I, Fred C. Arfman, NMPE No. 7322 of the firm Isaacson & Arfman, P.A. hereby certify that this project has been graded and will drain in substantial compliance with and in accordance with the design intent of the approved plan dated 5-6-13. The record information edited onto the original design document has been obtained by Benjamin M. Aragon, NMPS No. 15268. I further certify that I or a member of my firm under my direct supervision have visited the project site on 04-02-14 and have determined by visual inspection that the survey data provided is representative of actual site conditions and is true and correct to the best of my knowledge and belief. This certification is submitted in support of a request for permanent Certificate of Occupancy.

AREAS OF MODIFICATION BETWEEN APPROVED DRAINAGE GRADING PLAN AND ACTUAL AS-BUILT

GRADING & DRAINAGE PLAN

CG-101

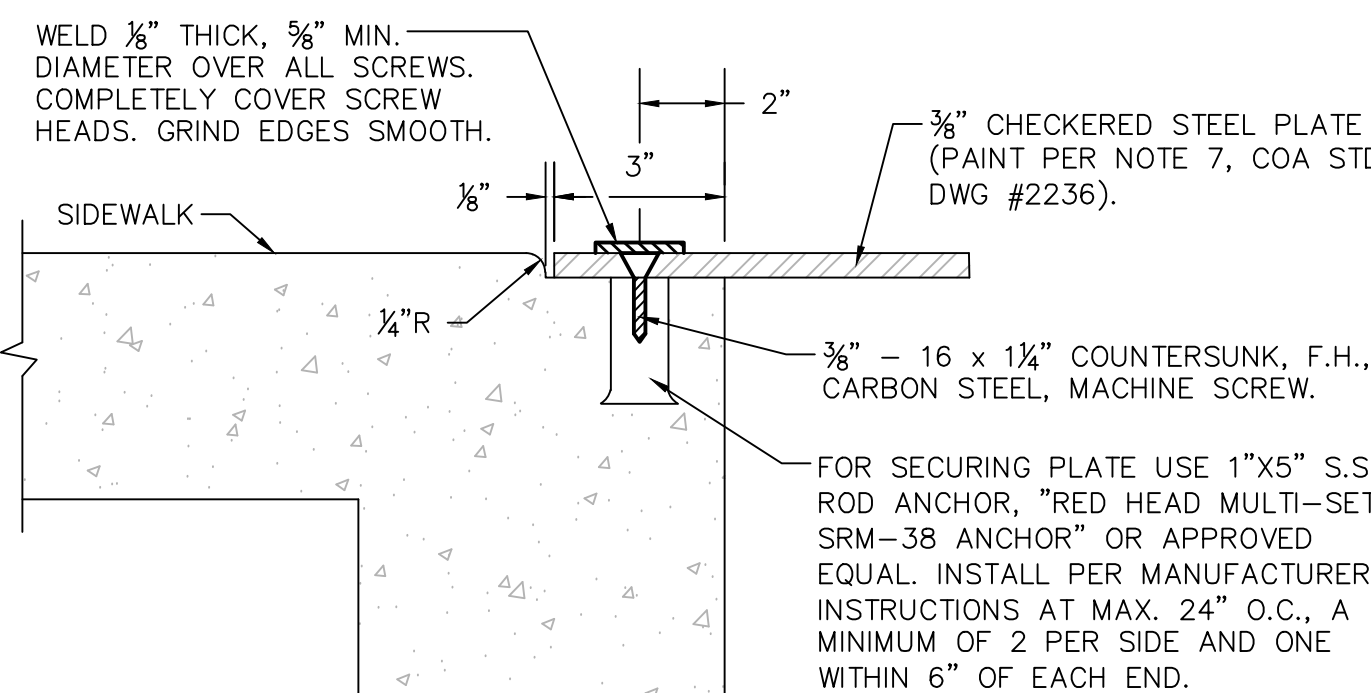
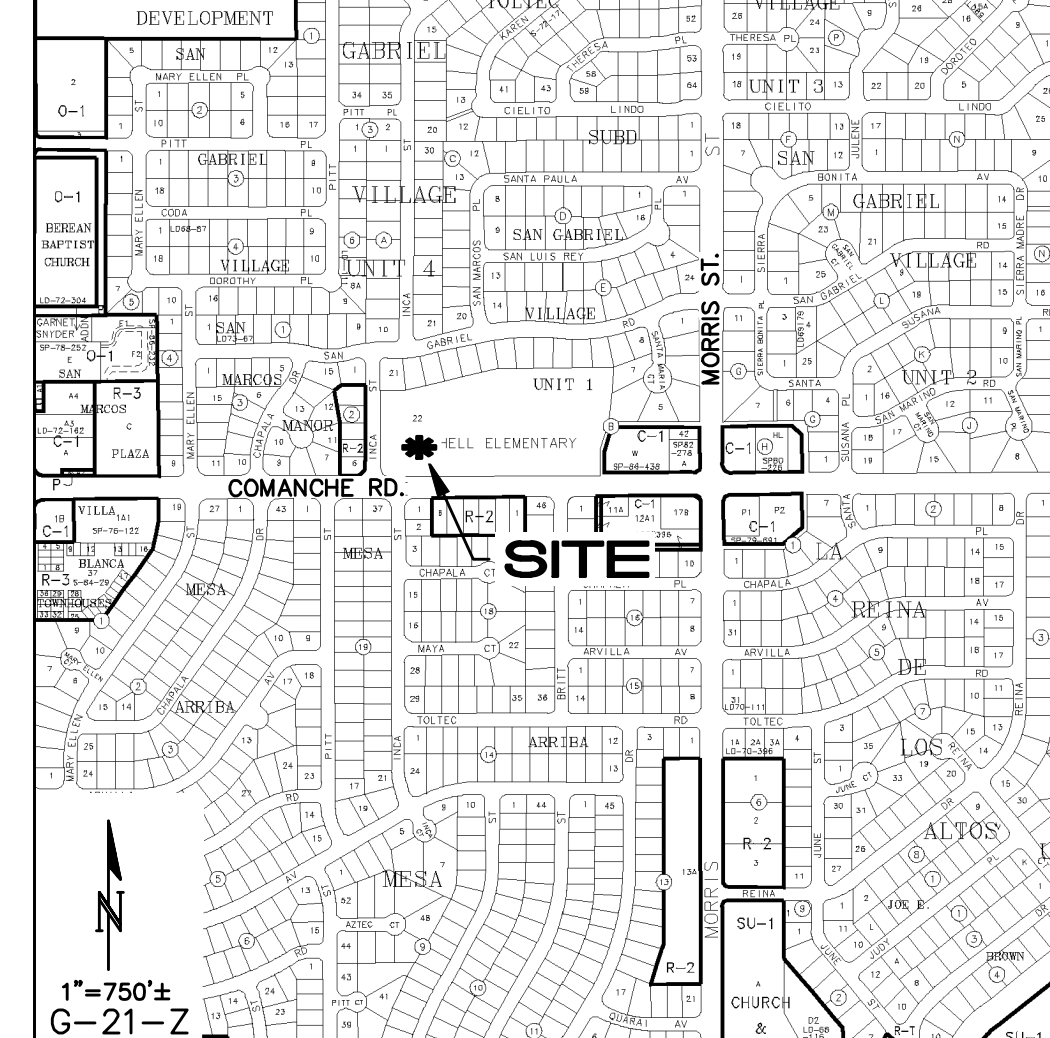
Landscaping rock swale with boulders constructed in place of grouted rock erosion protection (2 locations). Owner to maintain. OK
